**42 Honeysuckle Drive (SSD 10378)
Request for Additional Information**

I refer to the Response to Submissions (RTS) for 42 Honeysuckle Drive (SSD 10378). After careful consideration, the Department is requesting that you provide the following additional information:

General Arrangement Plan
Ground Floor Plan

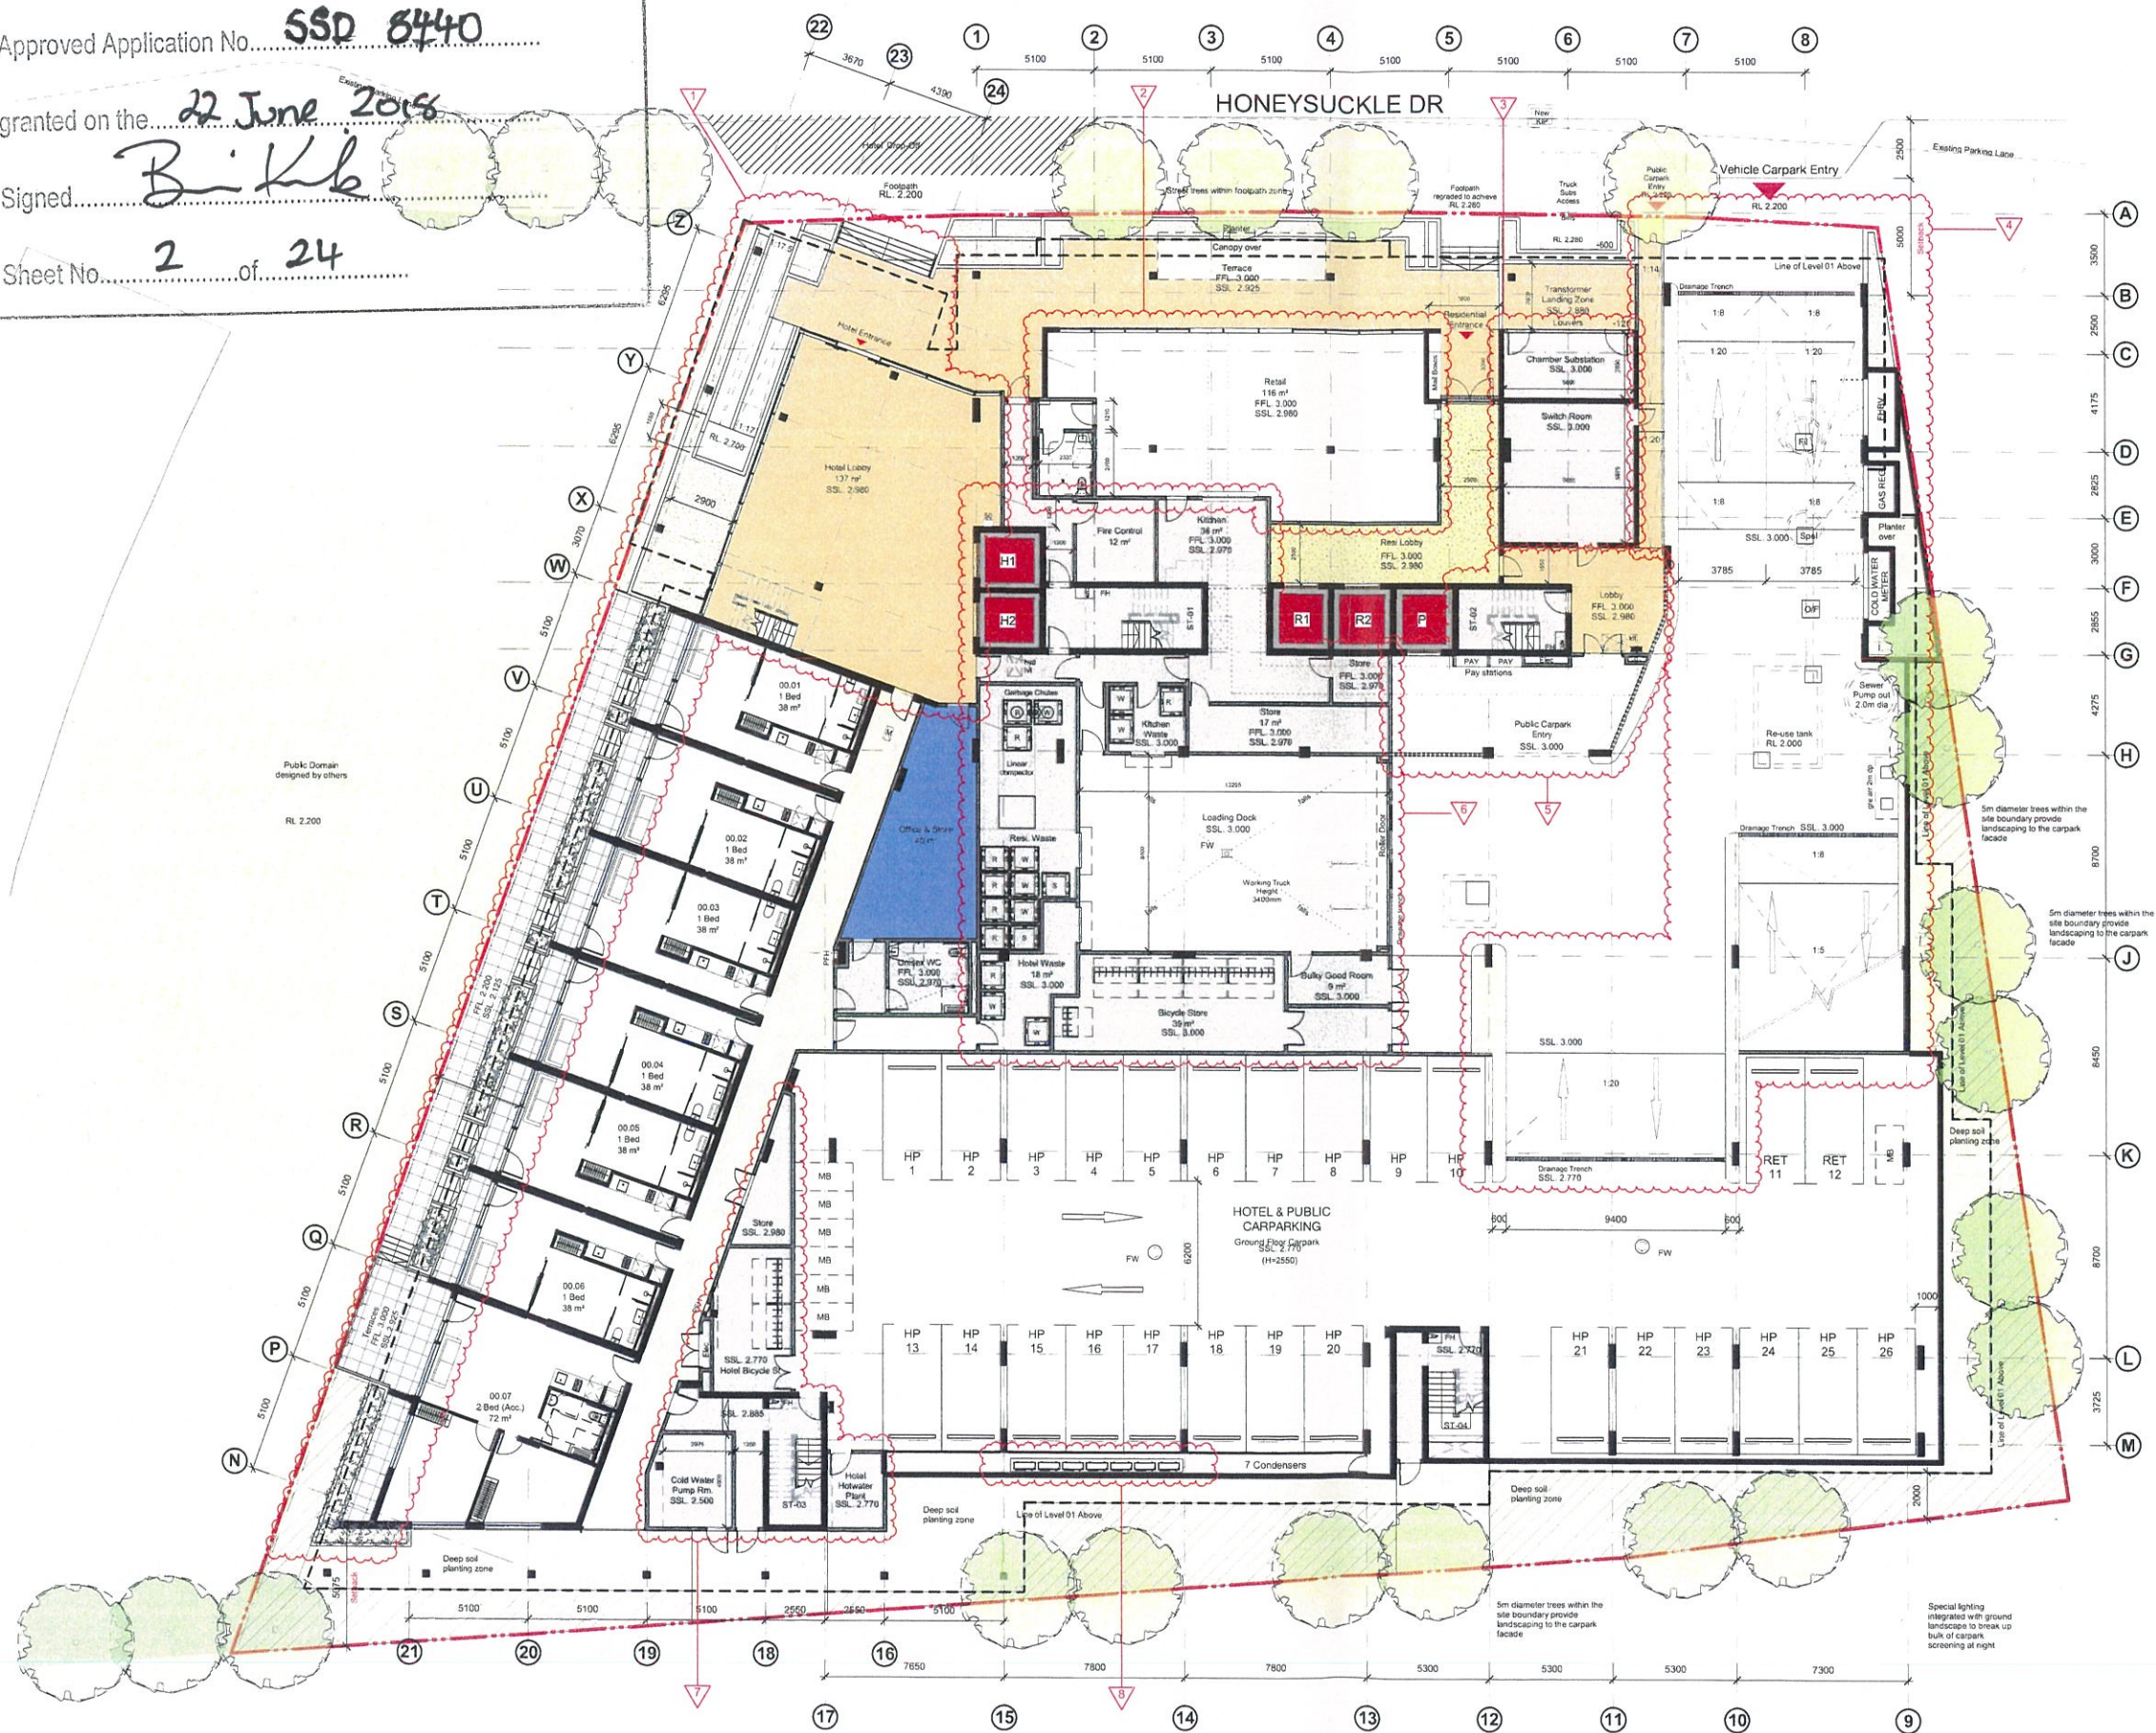
- amended plans showing the ground floor access a minimum height of 4.5m required for a medium rigid vehicle in accordance with AS2890.2.
- a satisfactory engagement agreement / statement of intent from the relevant commercial waste collection provider/s that the waste management services as detailed in the final Waste Management Plan can be conducted.
- details of alternative hotel drop off/ pick up and on street loading noting that the use of on-street bay is still subject to approval from Council's Traffic and Transport Team.
- further details about the public domain works to be included in a condition of consent
- a breakdown of the maximum number of patrons for each use, as requested in NSW Police's submission.
- amended plans showing the RL of natural ground line and measurements in AHD.
